Your ref: 3/2025/0207
Our ref: 2025/0207
Date: 7th April 2025

Address: Lower Abbott Bungalow, Abbott Brow, Mellor

Proposal: Proposed replacement driveway

The submitted documents and plans, including 'Proposed drawings 2414.03.01' have been reviewed and the following comments are made.

PROPOSED SITE PLAN

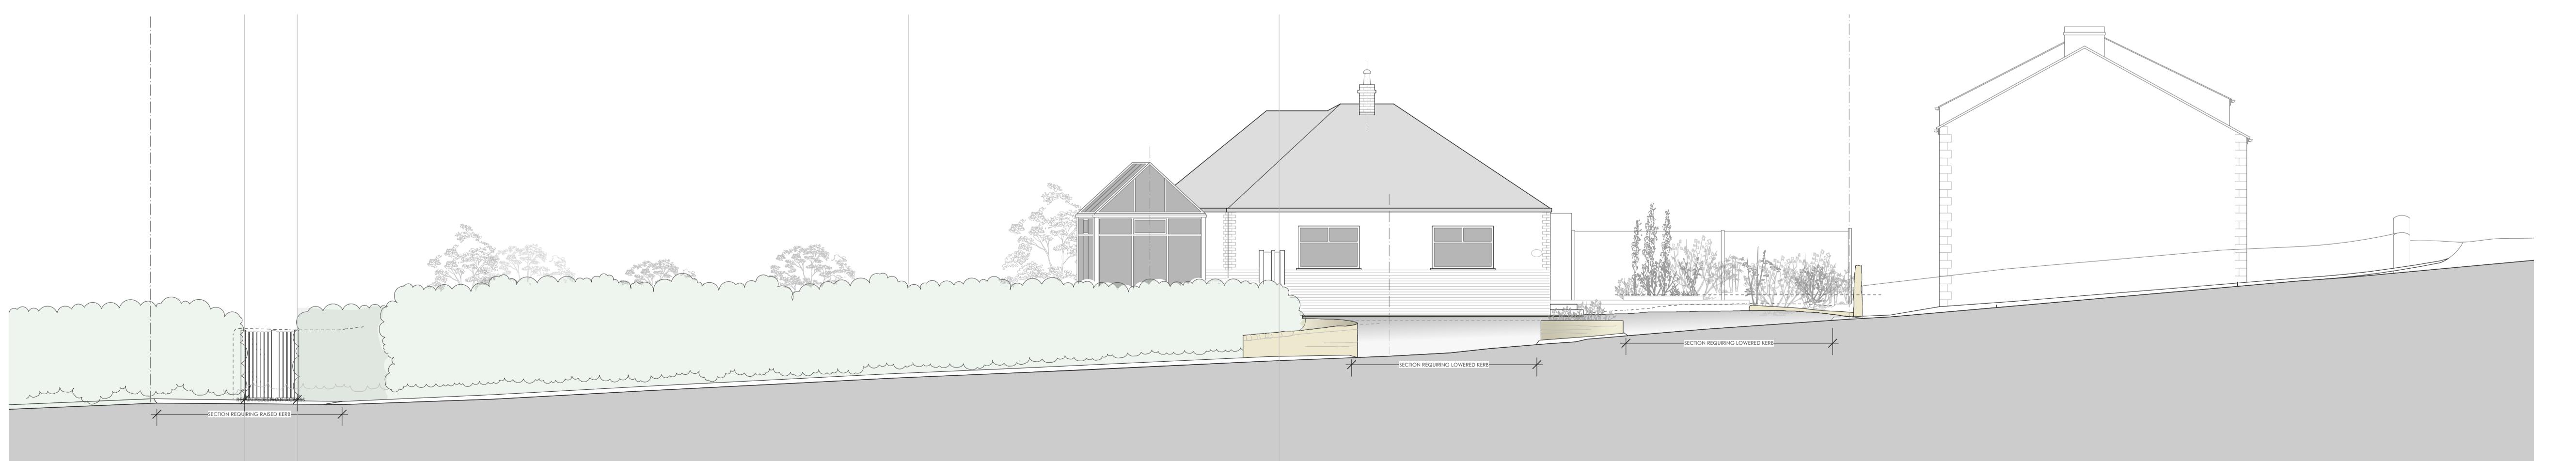
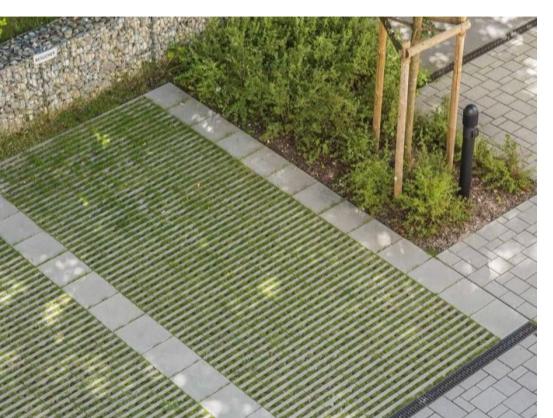
The visibility splay to the east side of the access lies across the splay for the adjacent access controlled by application 3/2023/0580 (Lower Abbott Barn – Conversion of Barn to dwelling) and subsequent condition discharge application 3/2024/0401 for demolition of part of the barn adjacent to Abbott Brow to improve visibility splays at the existing site access which is sited to the east of Lower Abbott Bungalow. It is noted that the demolition of part of the barn has been undertaken.

The visibility splay to the west side lies across the land controlled by the applicant.

The splays and proposed layout are considered acceptable.

The edge of the new driveway will need to tie-into the carriageway surface of Abbott Brow with a saw cut edge sealed with tack coat.

The driveway is proposed to be laid with grass crete or similar, this is acceptable subject to it being a bound and porous material.

The surface water road gully on Abbott Brow will require remain in-situ and protected with a small planted area.

The existing access will be physically closed with the dropped kerb reinstated to full height, tarmac strip converted to grass verge and boundary treatment reformed.

1. The new access shall be formed in accordance with the approved drawings and the driveway shall be constructed in a bound and porous material. Reason: For highway safety.
2. Prior to the first use of the new access, the existing access shall be permanently closed and the dropped kerb shall be reinstated to full height kerb and tarmac verge shall be reinstated to grass verge. Reason: For highway safety.
